WEST YORKSHIRE POLICE

Designing Out Crime Officer

To: Adam Walker	Ref: 2019/91630 Date: 28 th May 2019
-----------------	--

Site Location: Ruth Street, Newsome, Huddersfield HD4 6JF

Drawing No.
2968 / 2.240

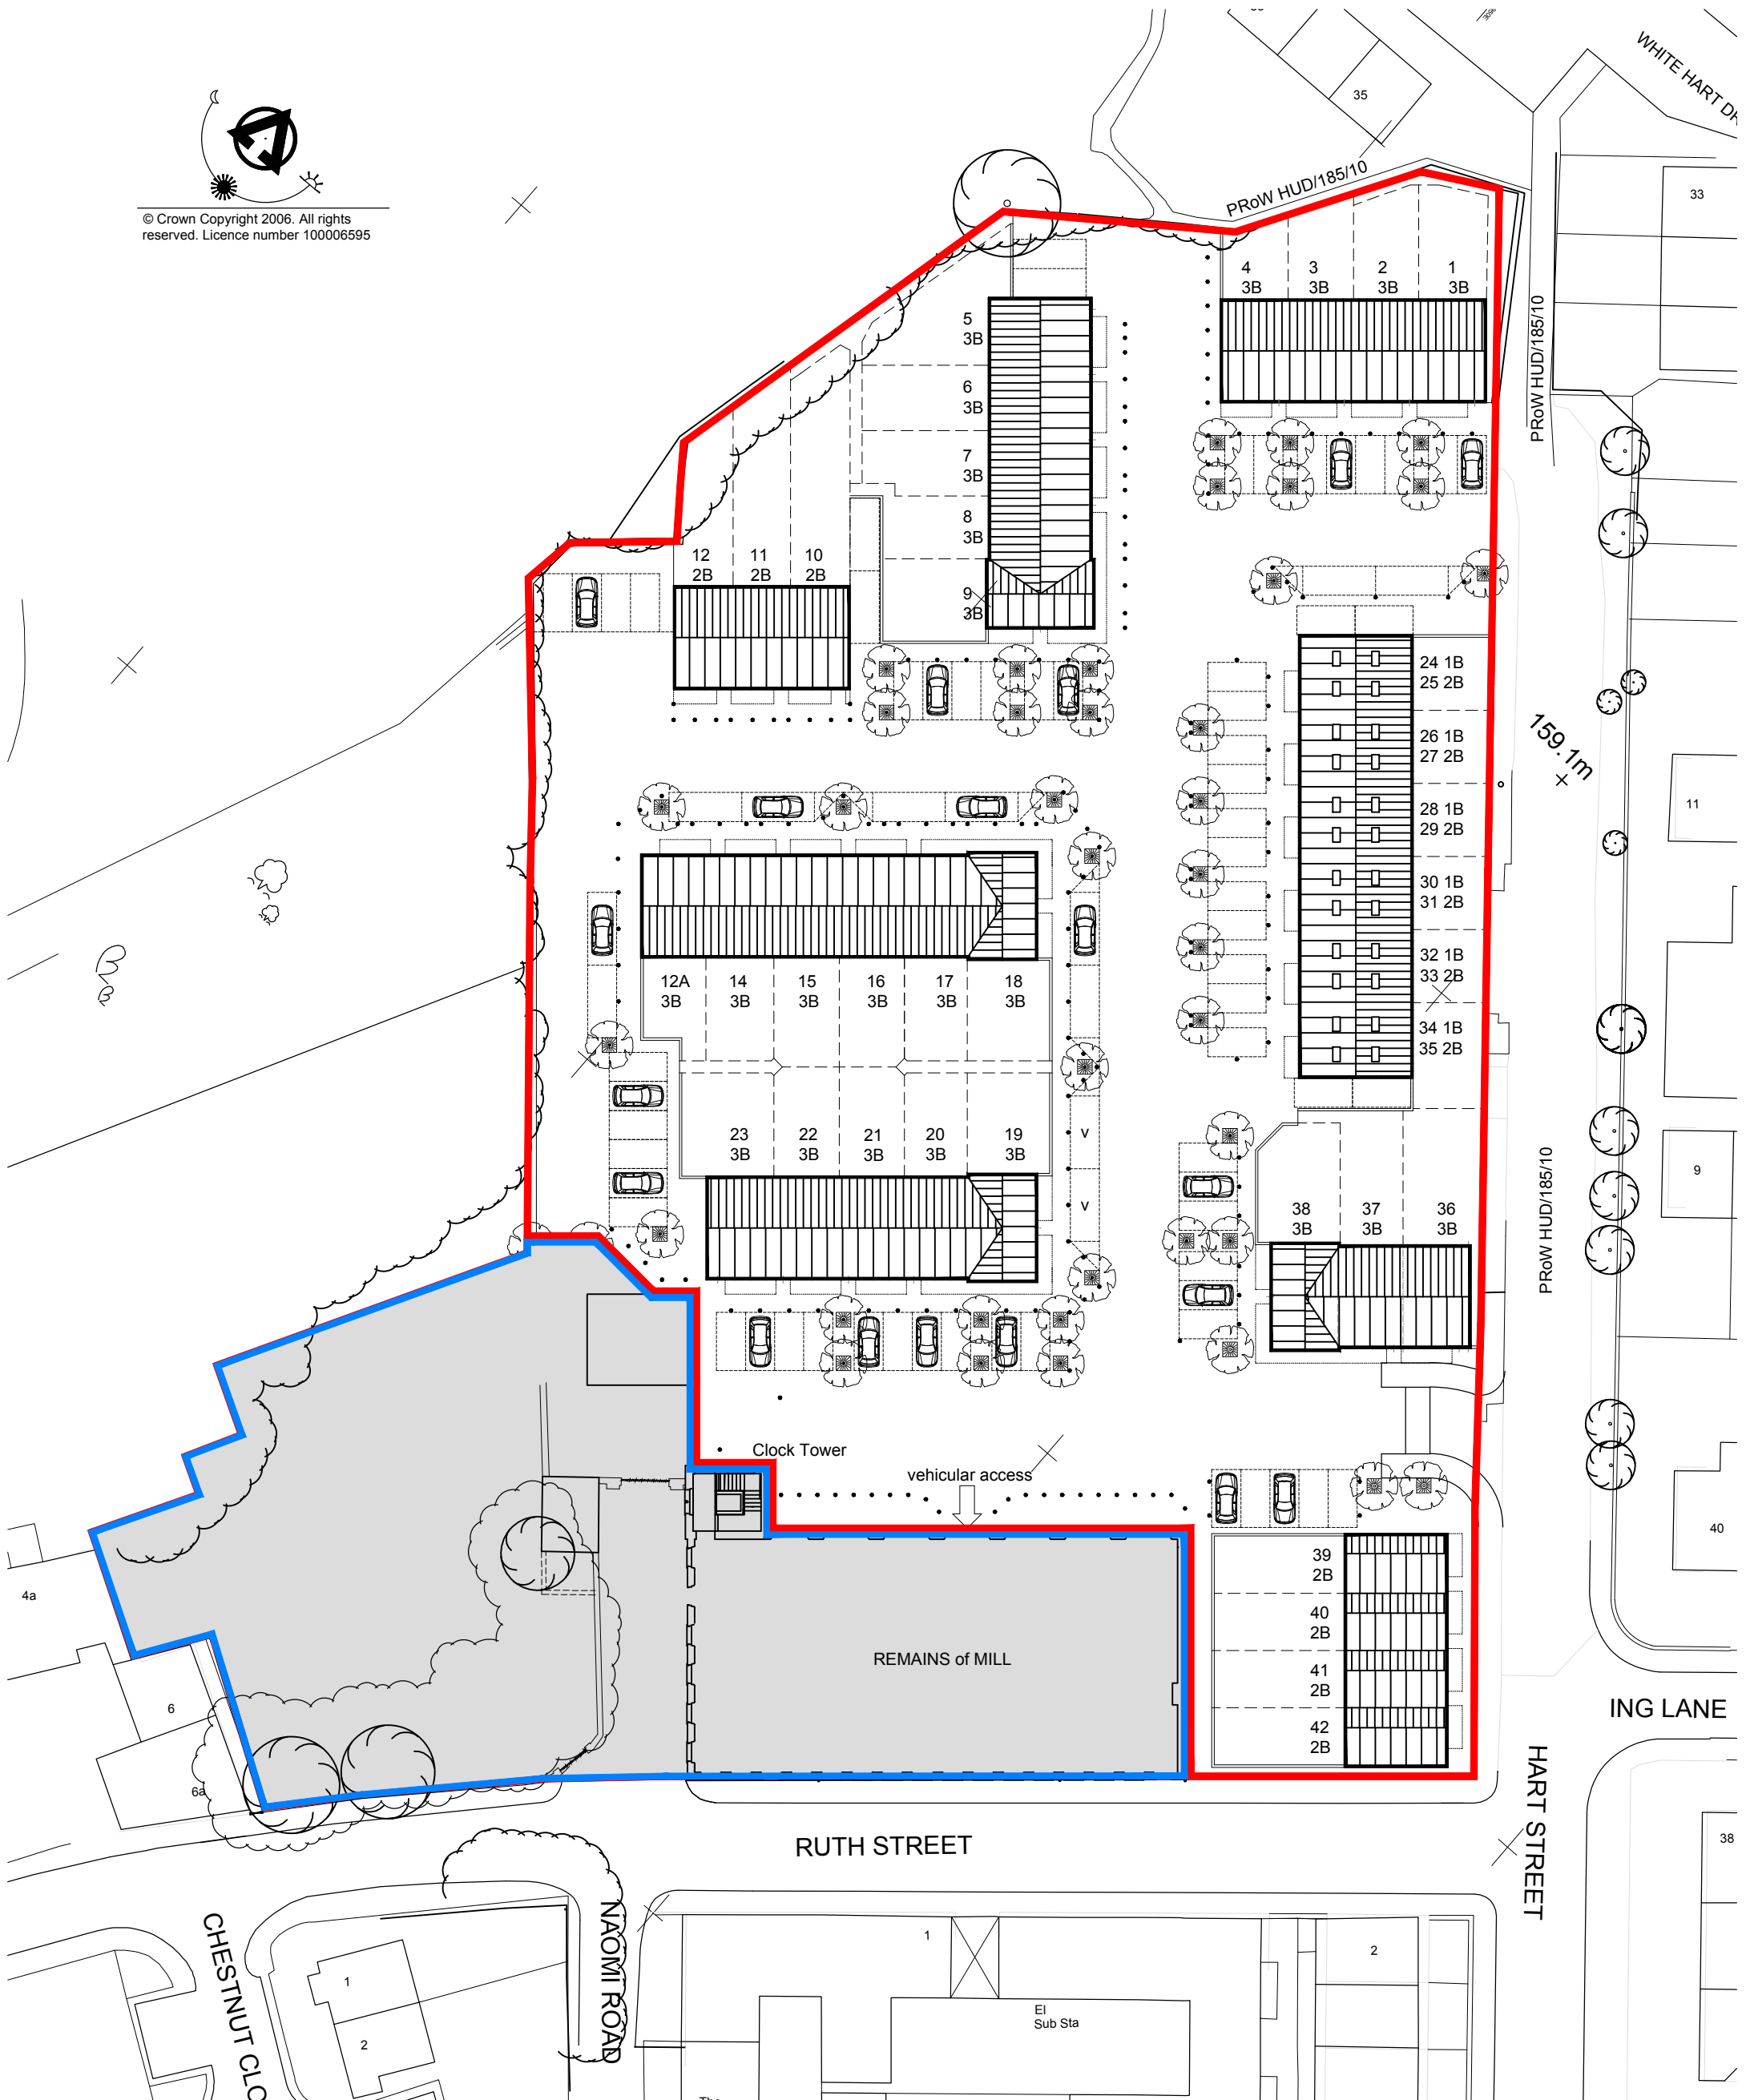
Referring to site plan drawing number 2968/2.240 dated 22/11/18.

It is recommended the rear boundary treatments for each plot are to a minimum height of 1800mm such as masonry materials, close boarded timber fencing or other durable materials. Rear plot dividers in height of 1800mm consisting of the same material as above should be installed between properties.

Access must be restricted from the front of each plot, especially each of the end plots, into the rear garden by installing a 1800mm high lockable gate. This gate should be positioned near to the front building line to eliminate recesses and to increase natural surveillance restricting unauthorised access.

Plots with open front gardens, should have a marked boundary that clearly distinguishes the private space of the garden, from the public space outside it. This should consist of hedge / low wall / fence / railings of around 1m in height.

Rear parking court areas hidden from view behind garden fencing are unacceptable. They are known to become associated with nuisance and anti-social behaviour as well as increasing the opportunity for car crime and rear access burglary.

Refuse bins must be placed behind a locked gate within the rear garden. These should not be sited near ground floor windows, low roofs or boundary fences, as they will provide a climbing aid for offenders.
